COLORADO GEOLOGICAL SURVEY

July 15, 2026

**Subject: Ben Lomand Mountain Village Preliminary Plan
El Paso County, CO; CGS Unique No. EP-26-0077**

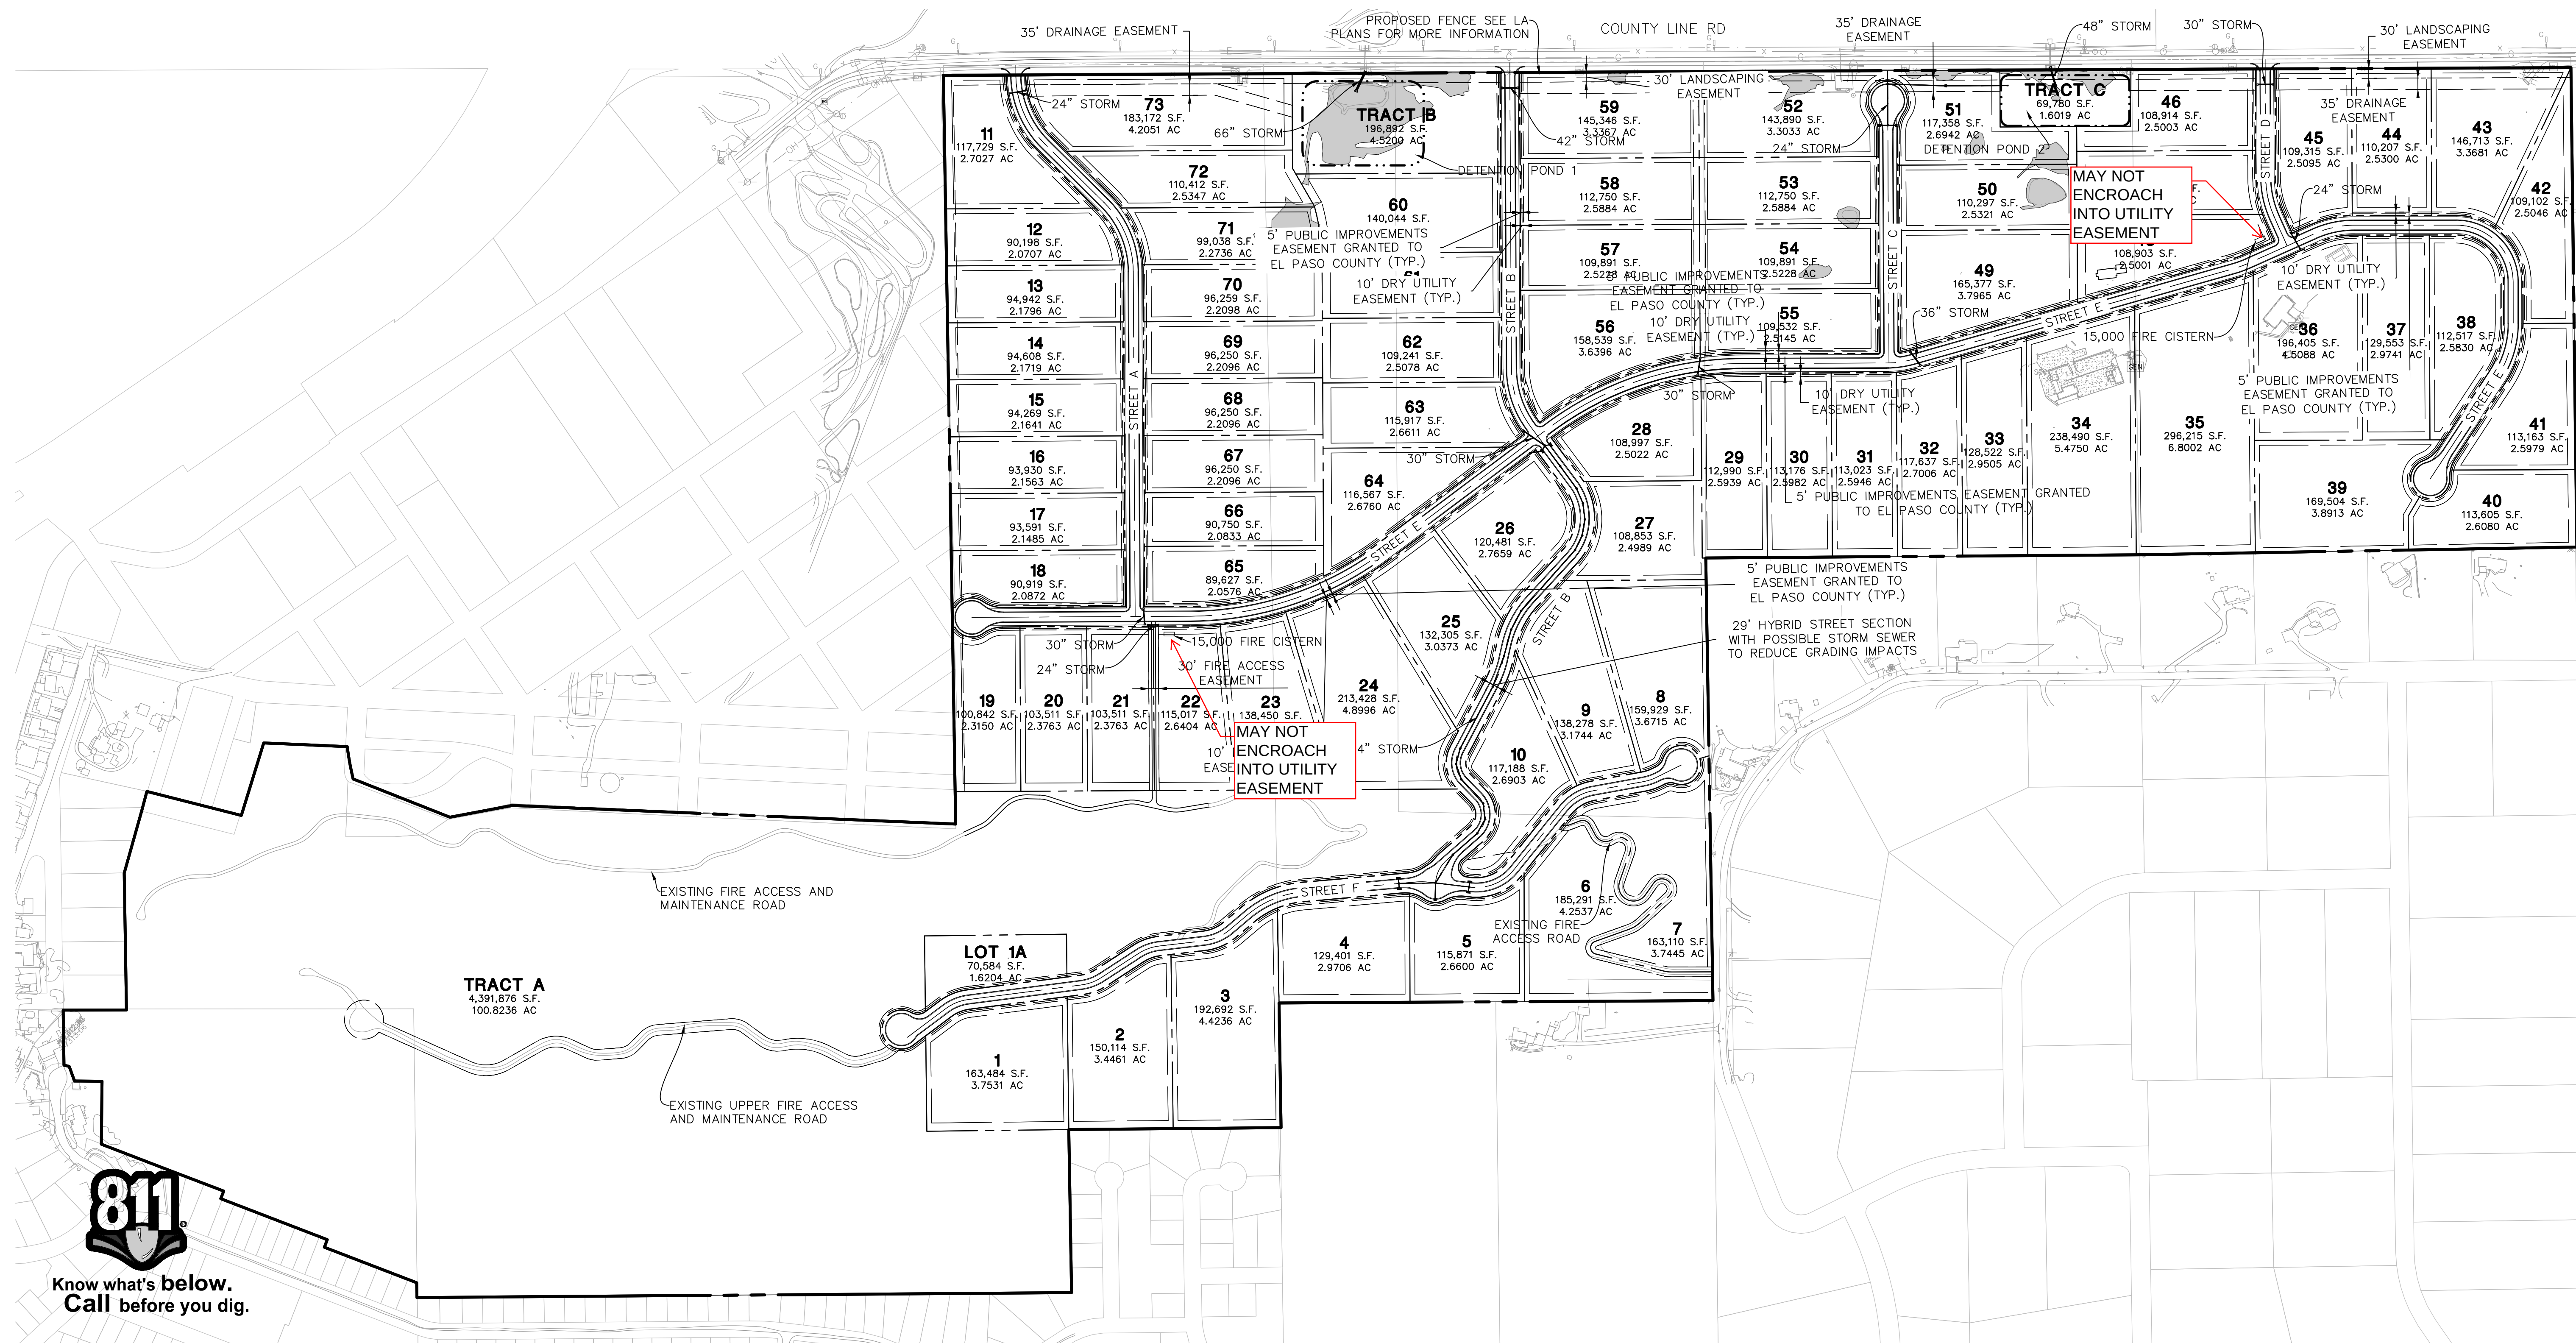
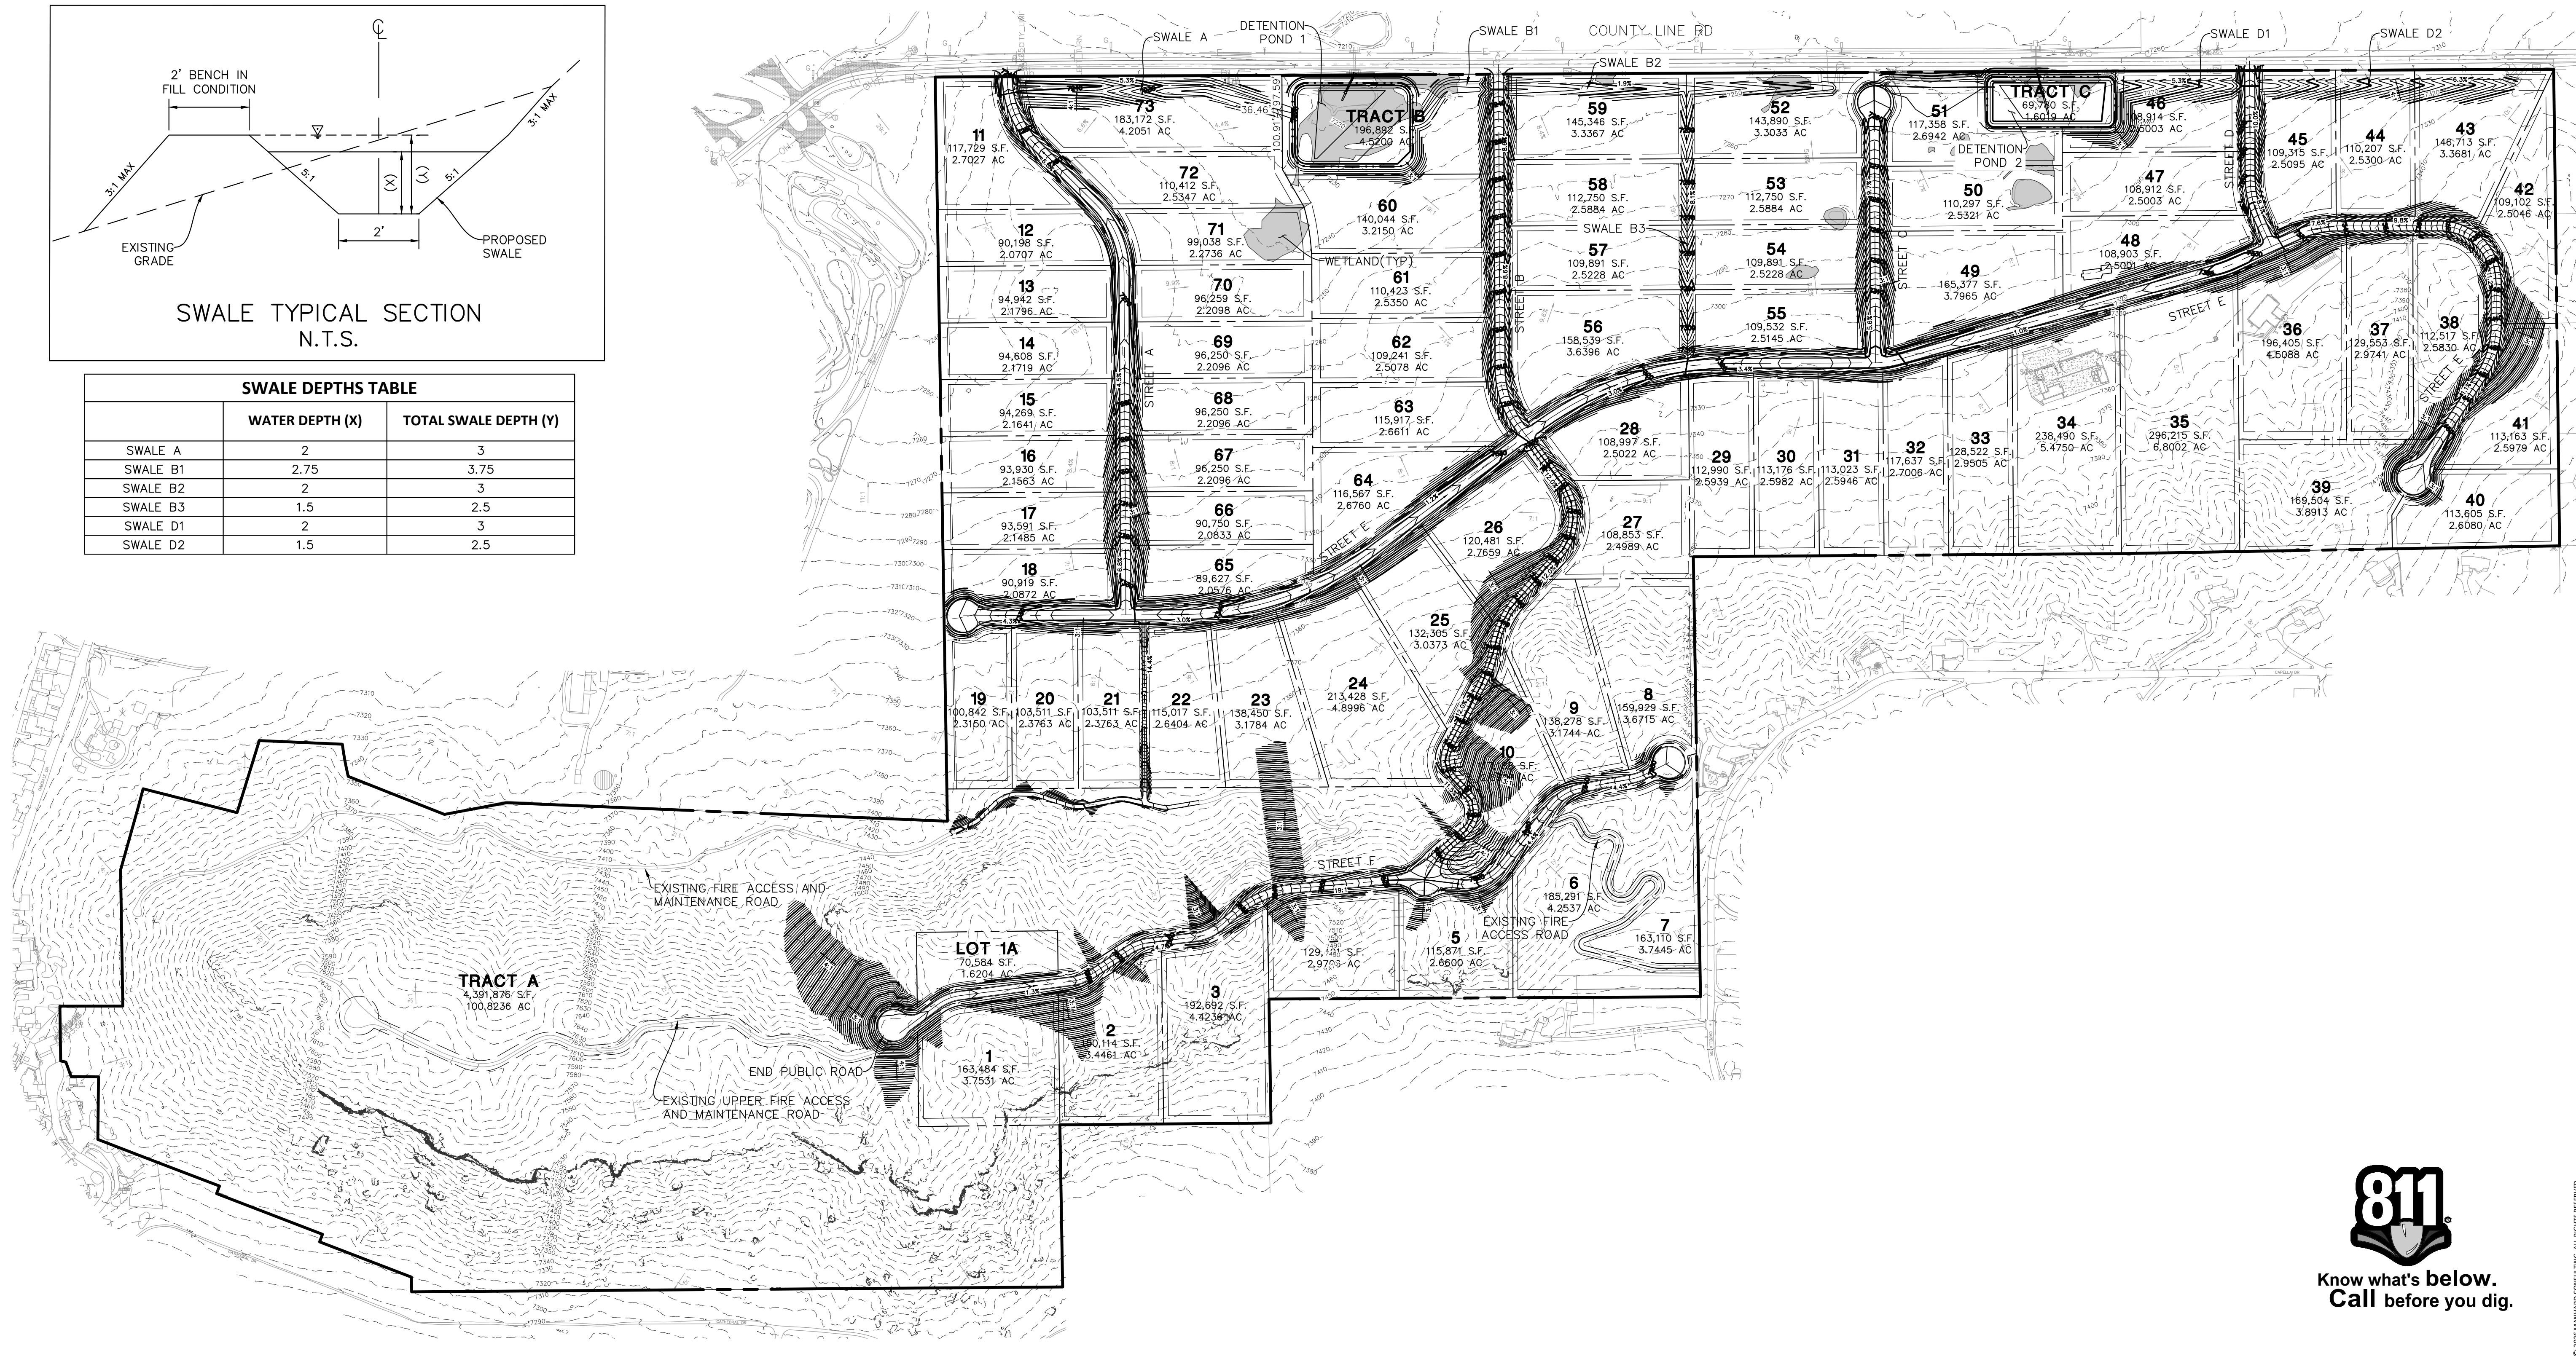
Construction-related slope instability: Steep slopes (30 percent and greater) are associated with Lots 1-11 and portions of Lots 20-44 (Overall Grading Plan). Steep slopes could result in construction-related instability. Slopes that appear to be currently stable can be destabilized by modifications such as excavation of cuts, the addition of fills, and loading from structures. RMG states (page 17), “Slopes greater than 30% are generally designated as “No-Build” zones.” CGS agrees with RMG that “Without additional slope stability analyses or rockfall studies, it is recommended the residences and detached structures maintain a minimum setback of 30 feet from the top and bottom of slopes exceeding 30 percent.” CGS recommends that this building setback from steep slopes (potentially unstable slopes) be noted in the preliminary plan.
